2 December 2025

REF: WTJ24 -549

**RE: AMENDMENT TO SSD-80018208 – PROPOSED DATA CENTRE
PROPERTY AT 6-8 JULIUS AVENUE, NORTH RYDE (LOT 89 DP1082131)**

1 DA GFA GROUND FLOOR PLAN
1:500

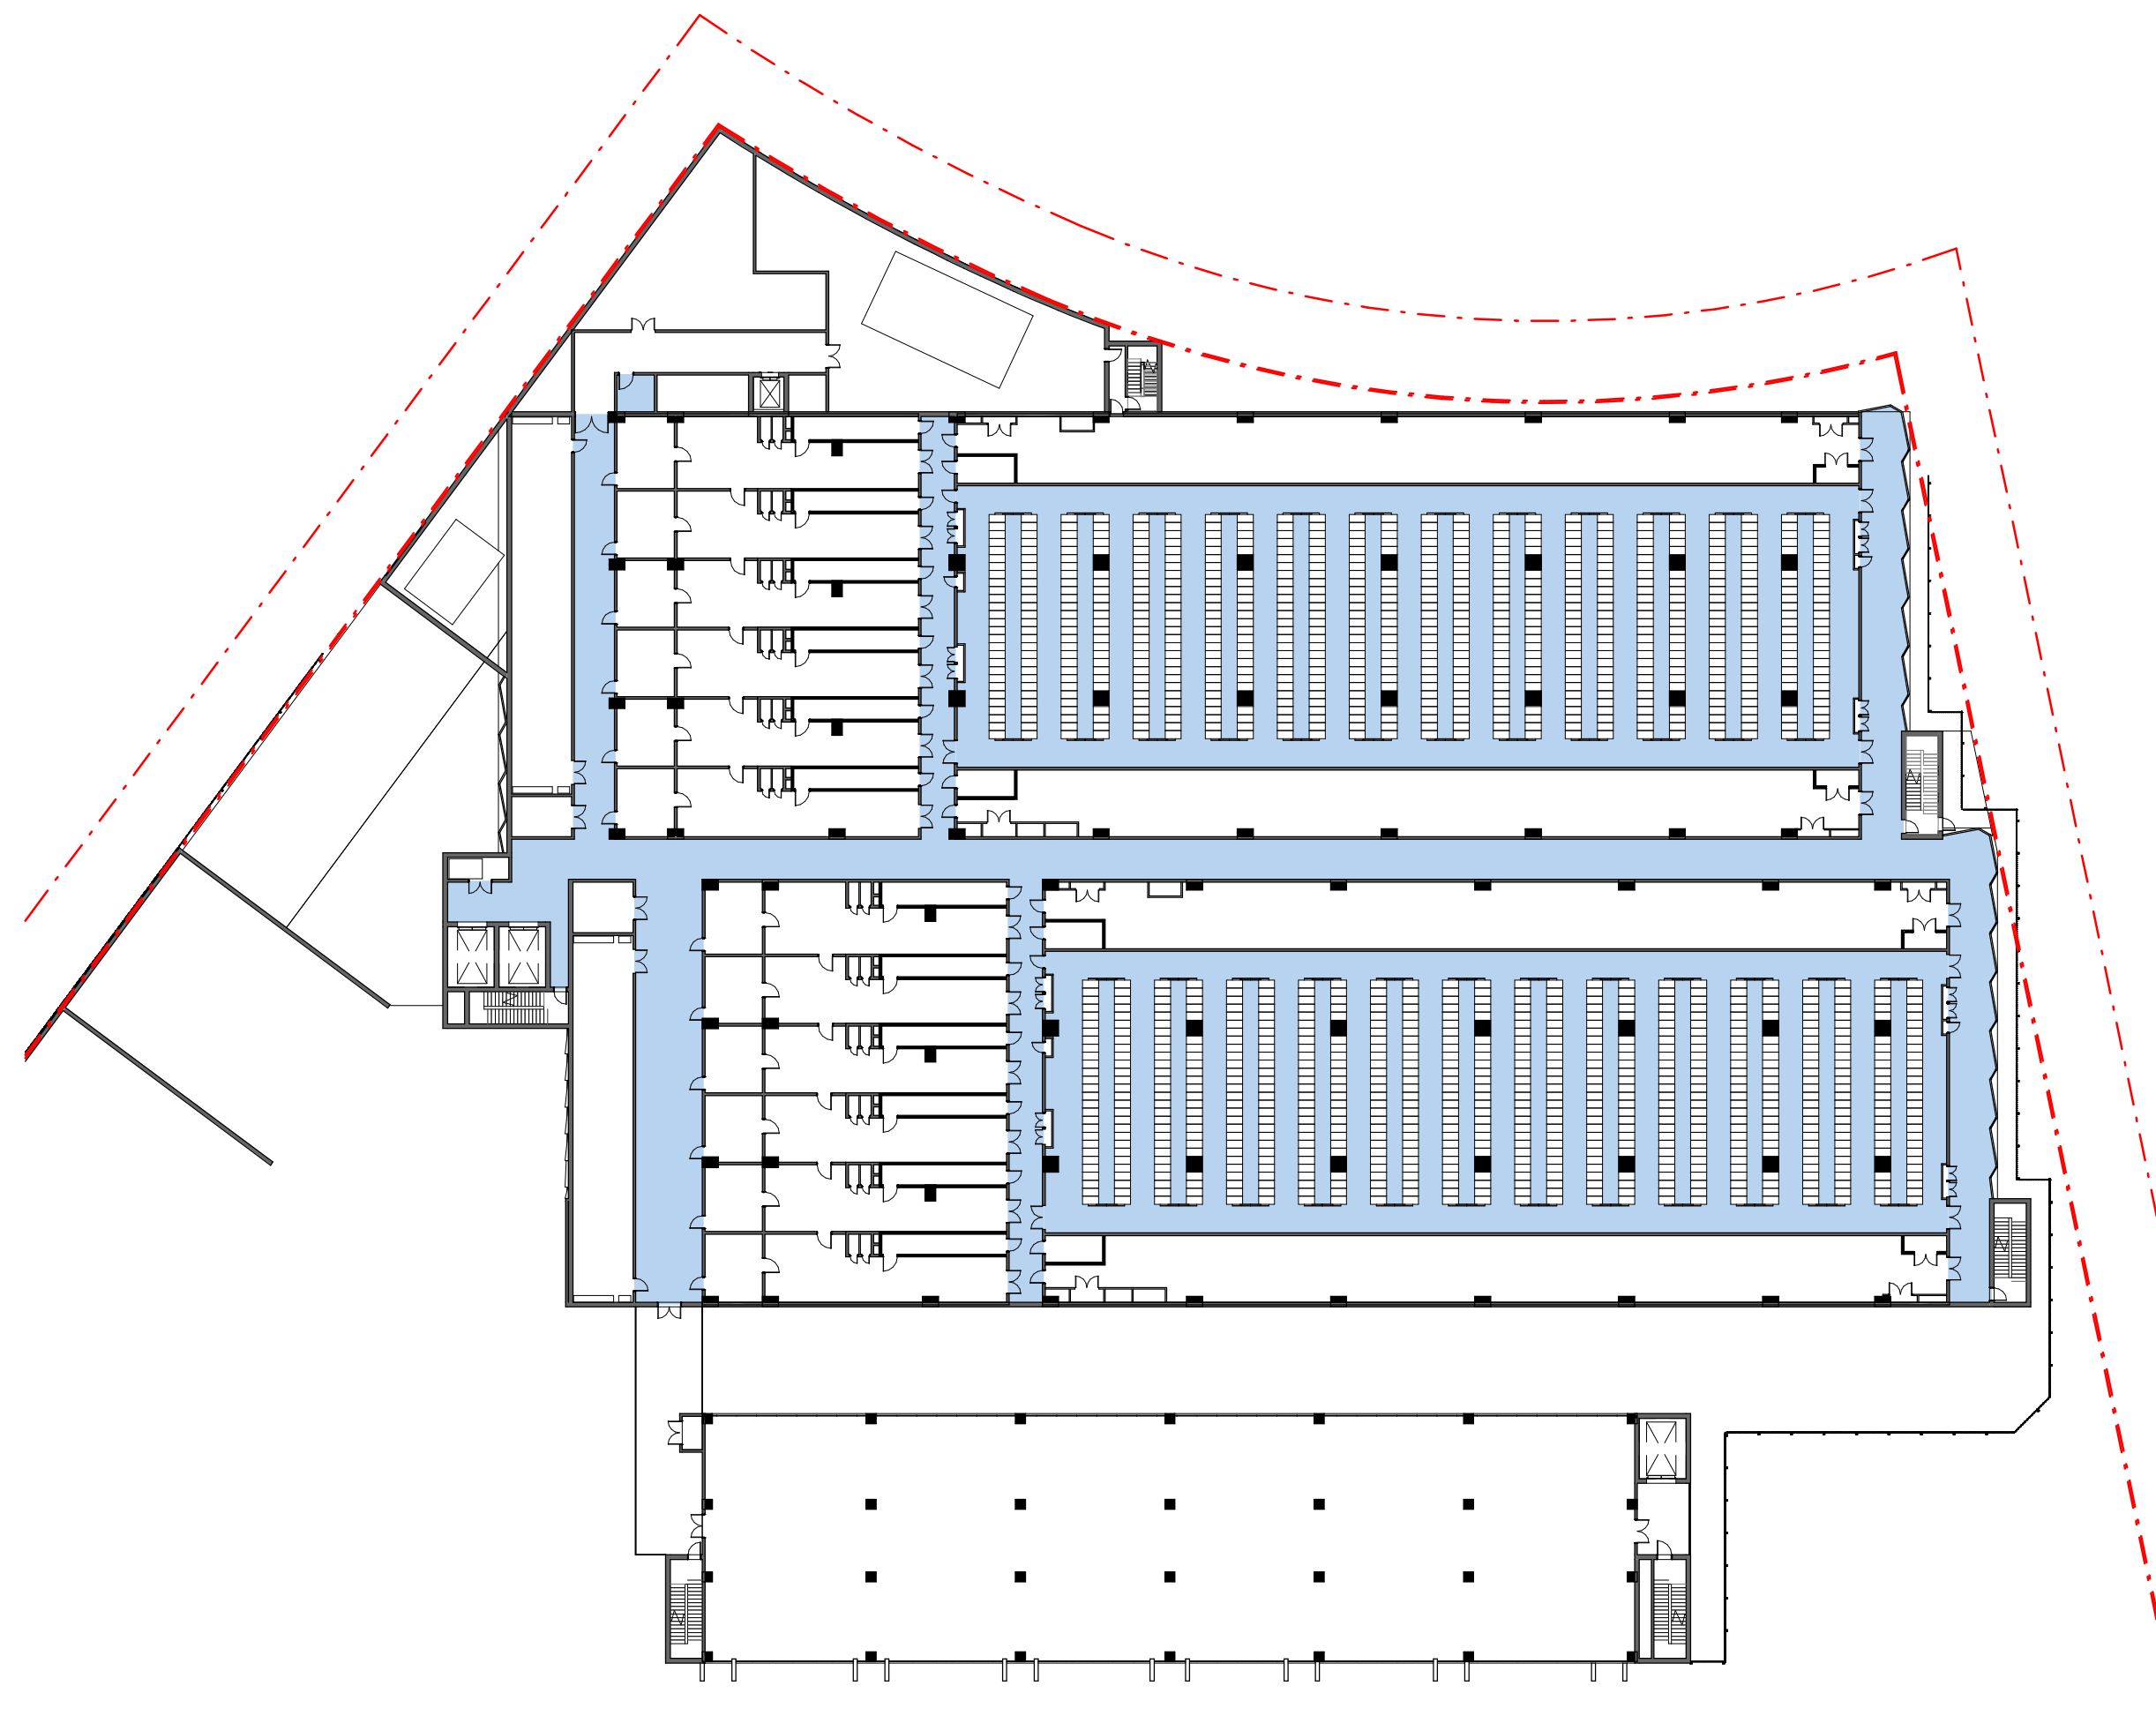
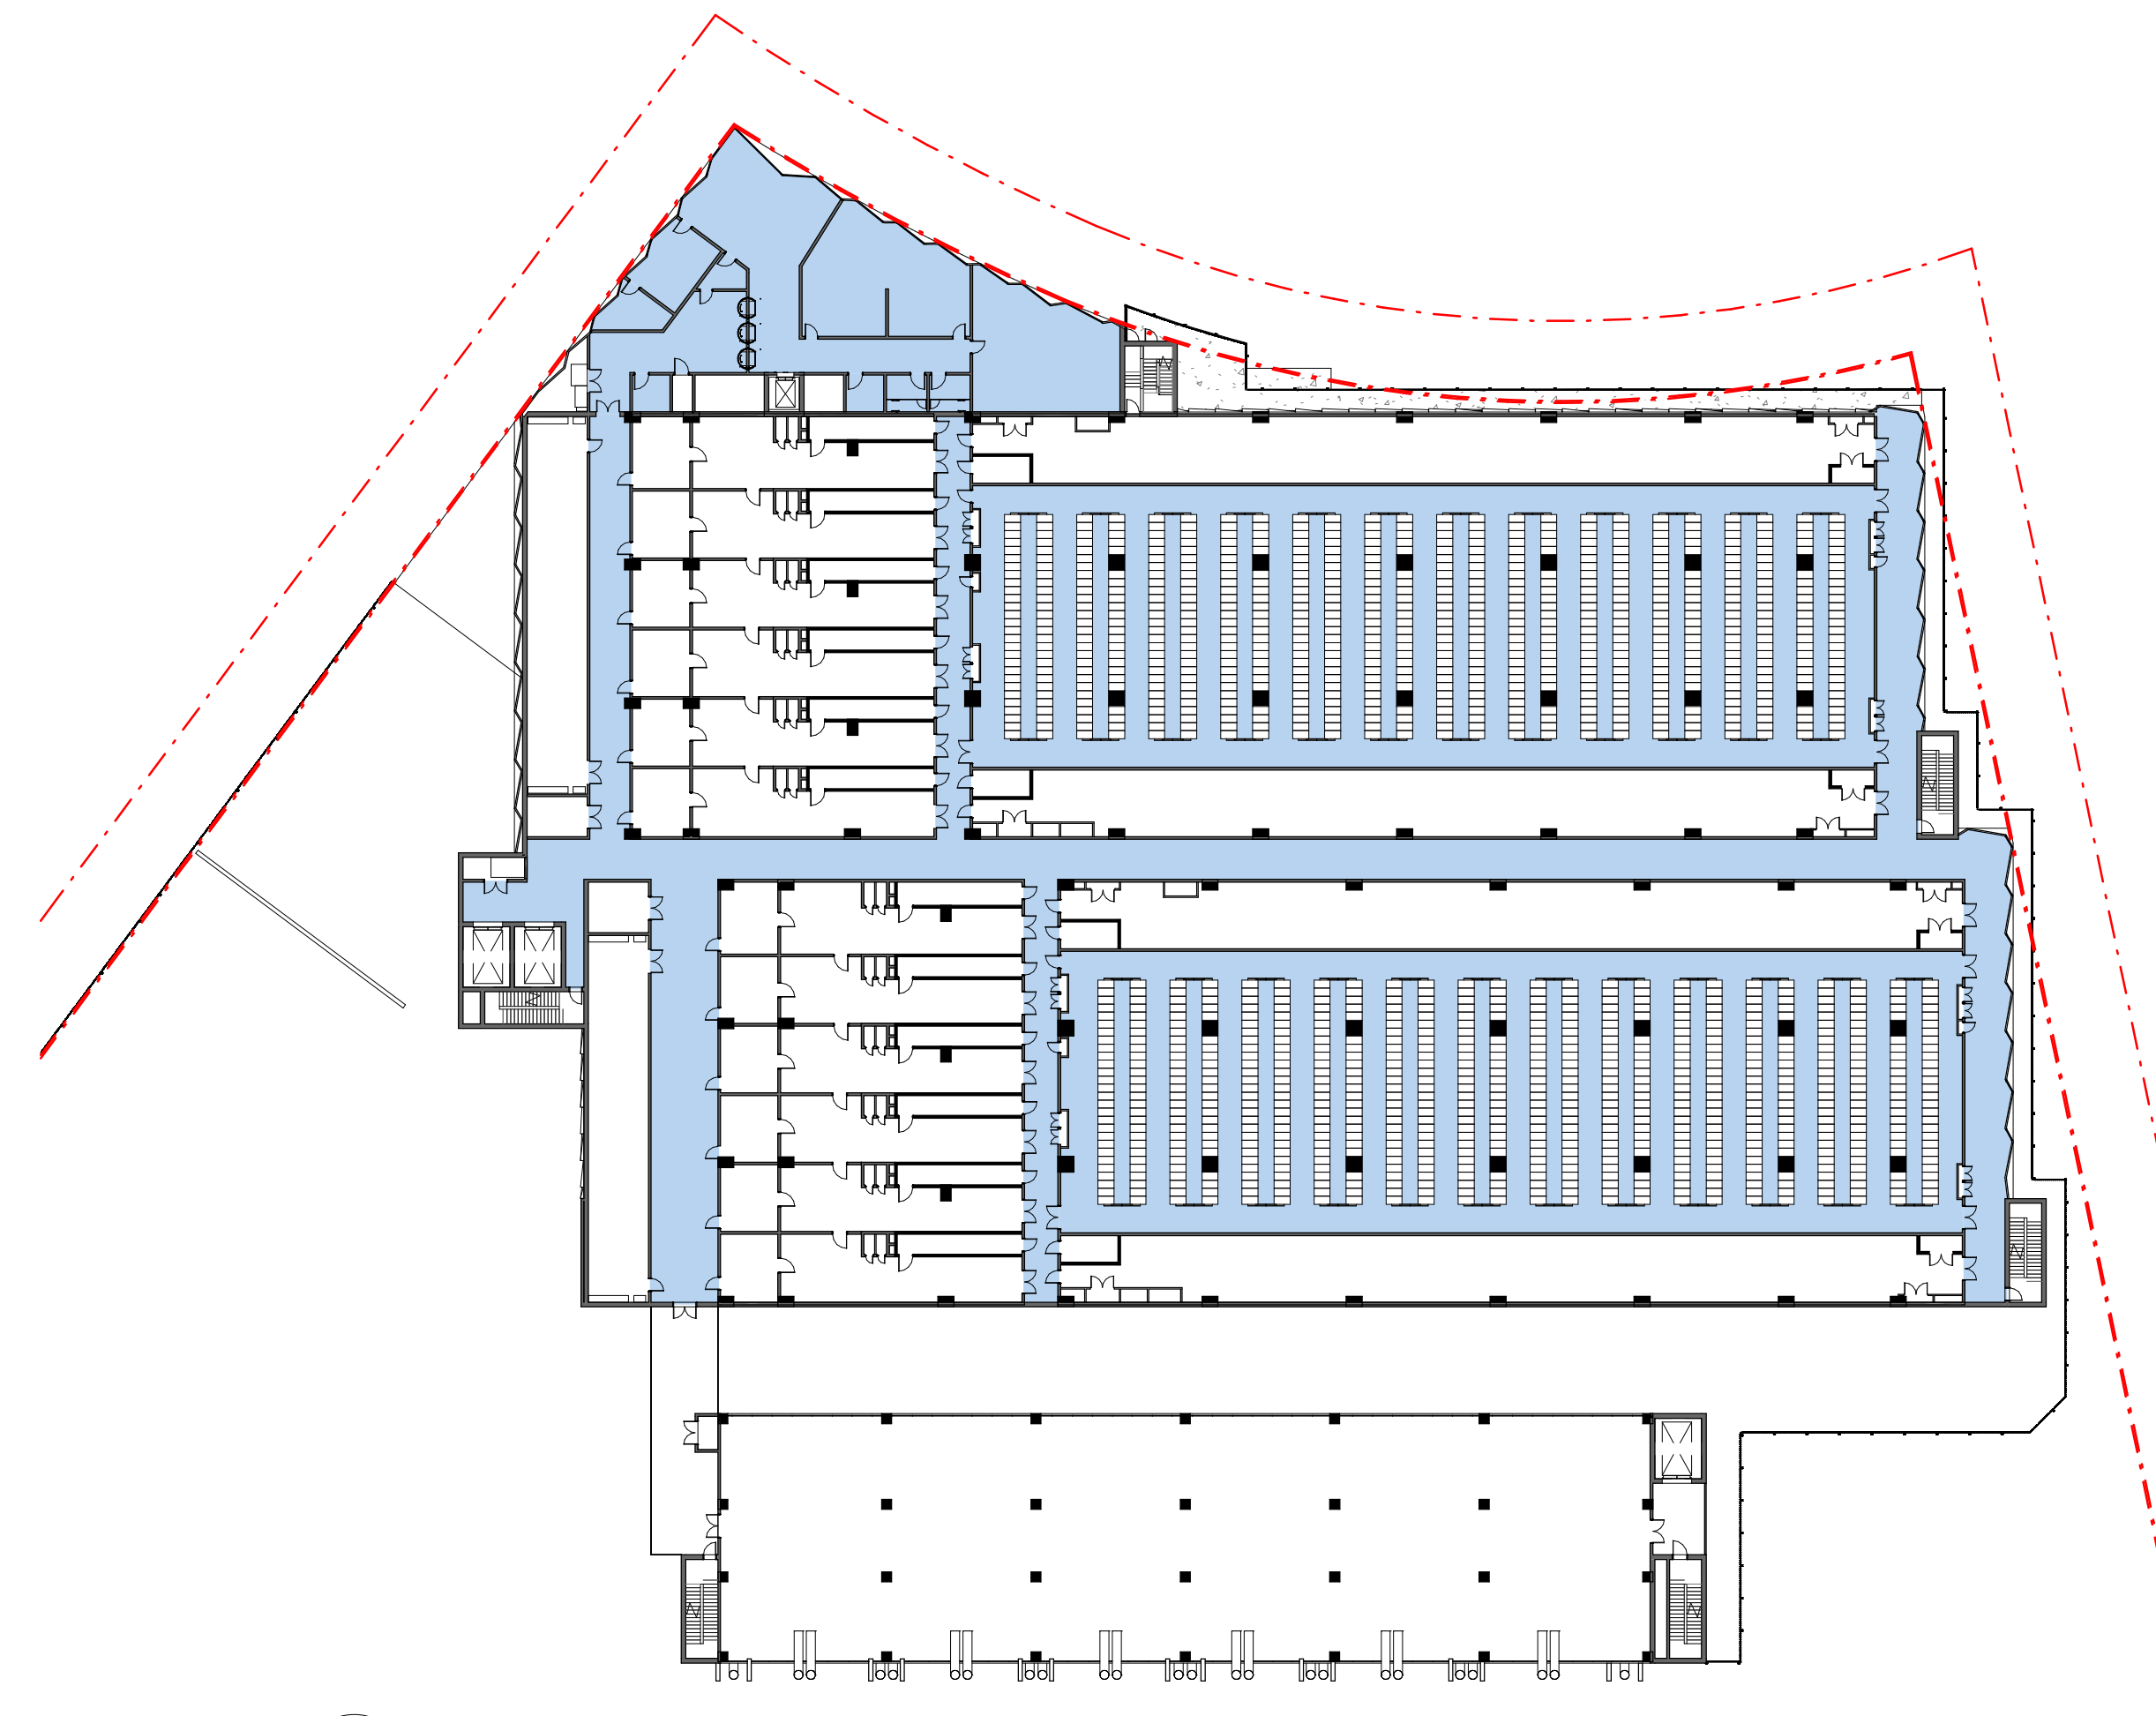
The development now has a reduced facility capacity (approximately 76MW, from 115.2MW) thus reducing consumption demands. Further, an amendment to the cooling methods of the facility has been proposed, with an adoption of air-cooled chillers, rather than the water-cooled chillers previously included. **TABLE 1** below summates the changes to operational measures of the proposed development.

TABLE 1. PROPOSED CHANGES		
Item	Previously Proposed	Proposed Through Amendment
Capacity	115.2MW	76MW, a reduction of approximately 34%.
Cooling Method	Water-cooled chiller level with rooftop cooling towers.	Single rooftop level comprising of air-cooled chillers.
Number of Storeys	6 storeys	4 storeys
Gross Floor Area (GFA)	26,076m ²	16,647m ²
Car parking	Basement level	Ground level

A reduction in capacity and the change to cooling methods allows the deletion of the former Level 6 chiller and deletion of the former basement level (as water storage tanks are no longer required).

Basement car parking has been relocated to the ground level adjacent to the proposed loading dock. As the site is zoned E3 under the RLEP 2014, Clause 6.7 applies, restricting ground floor development to commercial activities, and parking would be inconsistent with this requirement. The City of Ryde highlighted this technicality and provided advice that the parking is at ground level but not perceivable from street level due to the site's topography, and is therefore considered acceptable. The site has undergone major earthworks, with the actual ground floor situated more than 12 metres below Julius Avenue and aligning with the existing cut level.
